Comment Log for Rolling Meadows Channel & Floodplain Modification - 60% Design Plans

REVIEWERS			MATRIX RESPONSE			REVIEWERS' RESPONSE		
Reviewers: El Paso County Engineering & El Paso County Stormwater			3/1/2023		Disposition Key: A = Will Incorporate, B = Will Evaluate, C = Will Incorporate in Later Submittal, D = Other		Date: 3/06/2023

| DESIGNED BY: TKM | SCALE: HORIZ 1" = 500' | DATE ISSUED: JANUARY 2023 | DRAWING No. EC01 |

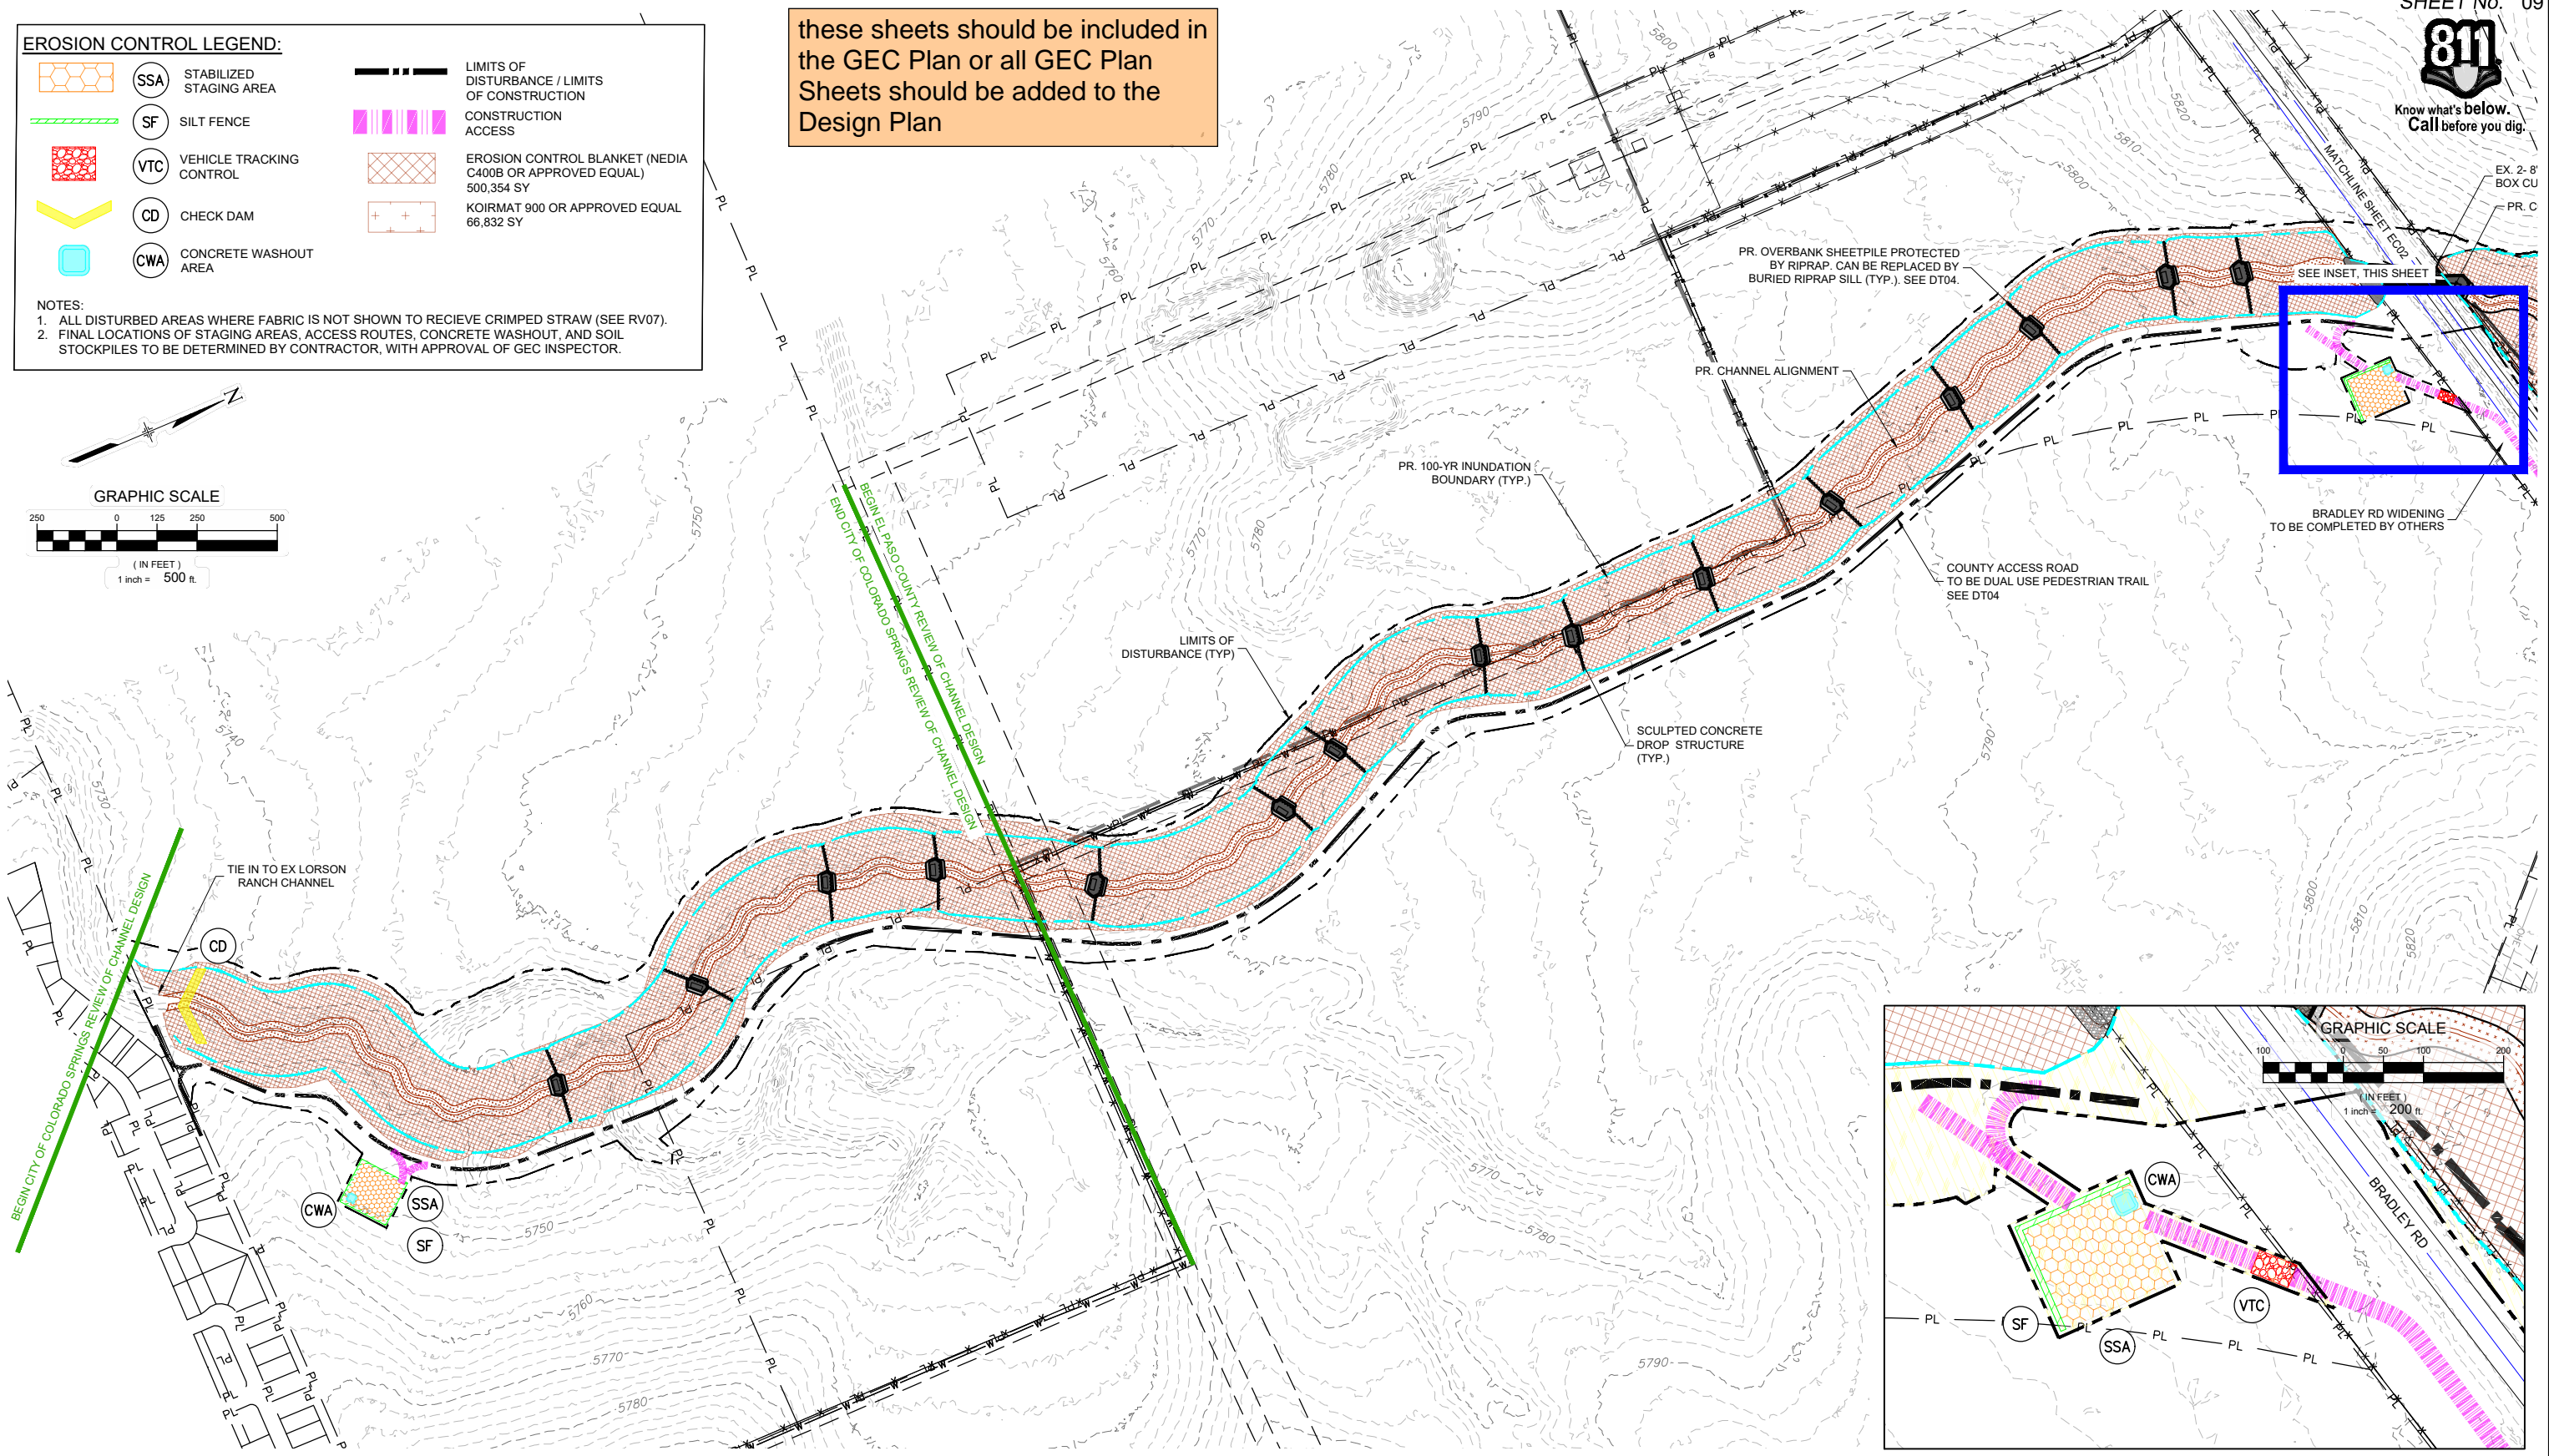
7	HZ01/02	Alignment table or centerline labels will need to be added on this sheet or on the plan & profile sheets	EPC Engineering	A	Line & curve tables added on HZ03	EAL	Add line and curve labels to HZ01 and HZ02	CD/JR
8	EC01	These sheets should be included in the GEC Plan or all GEC Plan Sheets should be added to the Design Plan	EPC Stormwater	A	Removed	EAL	Add these sheets to GEC Plan?	CP
9	PP03	Move scale off of text	EPC Engineering	A	Label moved	EAL	✓	JR
10	PP03	Show existing maint. trail	EPC Engineering	A	Ex. Maintenance trail showing	EAL	✓	JR
11	PP03	Label beginning of construction	EPC Engineering	A	Label added to Plan and Profile view	EAL	See comment about transition/tie-ins	JR
12	PP03	Per ECM Section 3.3.3.K.1 for channels longer than 1000 ft, ramps need to be provided to bottom of channel every 500 ft	EPC Engineering	C	Can you clarify? The standard reads that this is for channels greater than 10 ft deep AND 1,000 ft in length. Per DT01, our max depth is less than 10 ft. so does this apply? If required, we can incorporate this at 90%.	TKM	If access is provided to each drop structure that will be fine.	JR

| CHECKED BY: AJS | VERT. 1" = 20' | SHEET 25 OF 48 | PP15 |

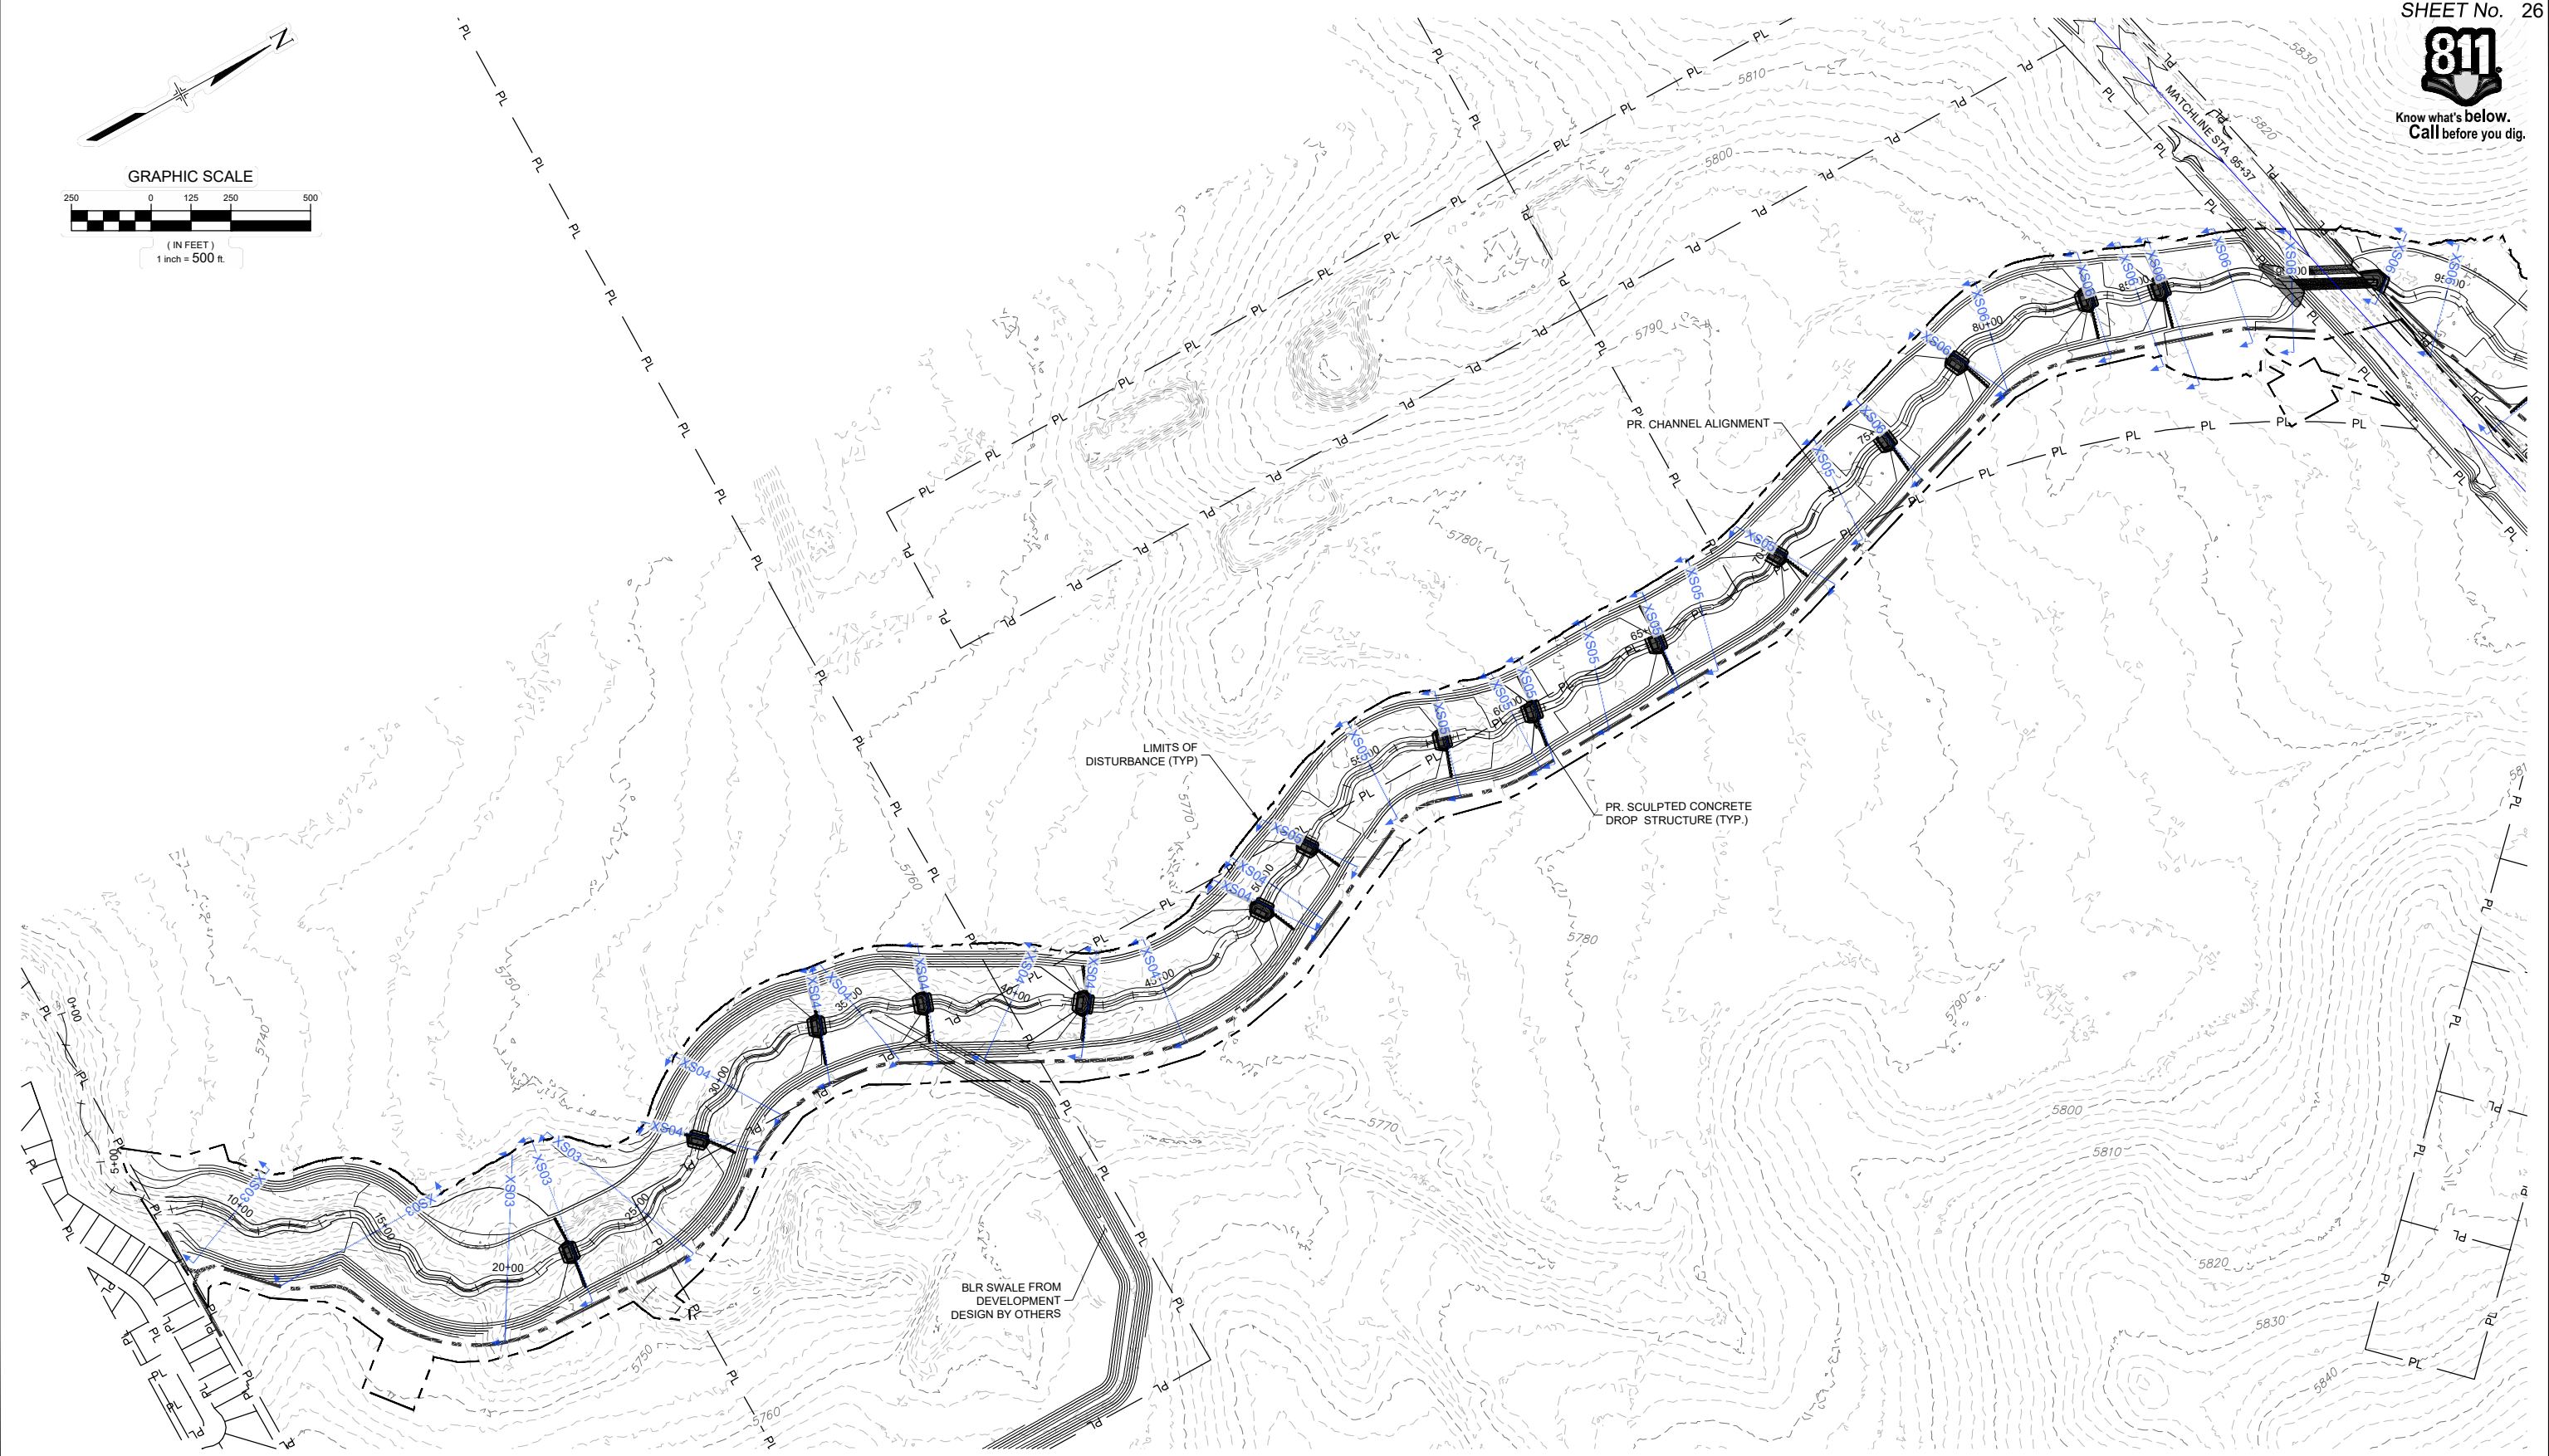
28	PP15	Provide a section through Drennan Road showing ROW width, pavement, shoulders, culverts etc.	EPC Engineering	A	Incorporated the survey data that we have.	TKM	Ok for this submittal	JR
29	XS01/02	Please show the proposed floodplain	EPC Engineering	A	100-yr floodplain extents added	EAL	✓	JR
30	DT01	label slopes	EPC Engineering	A	0% slopes labeled	EAL	✓	JR
31	DT01	On plans it looks like only 1' of rise at the ends.	EPC Engineering	B	Note added, floodplain extents vary based on channel hydraulics	EAL	✓	JR
32	DT01	Deviation request for low-flow channel should be submitted to finalize that aspect of design.	EPC Engineering	C	Our base flow channel is not intended to be the "low flow" channel. The flow identified at Q _{low} meets EPC requirements.	EAL	We need to document approval of the base flow/low flow design in a deviation since it is "non-standard" per EPC criteria.	JR
33	DT03	On plans it looks like only 1' of rise at the ends.	EPC Engineering	B	Note added, sheetpile extents vary based on channel hydraulics	EAL	✓	JR
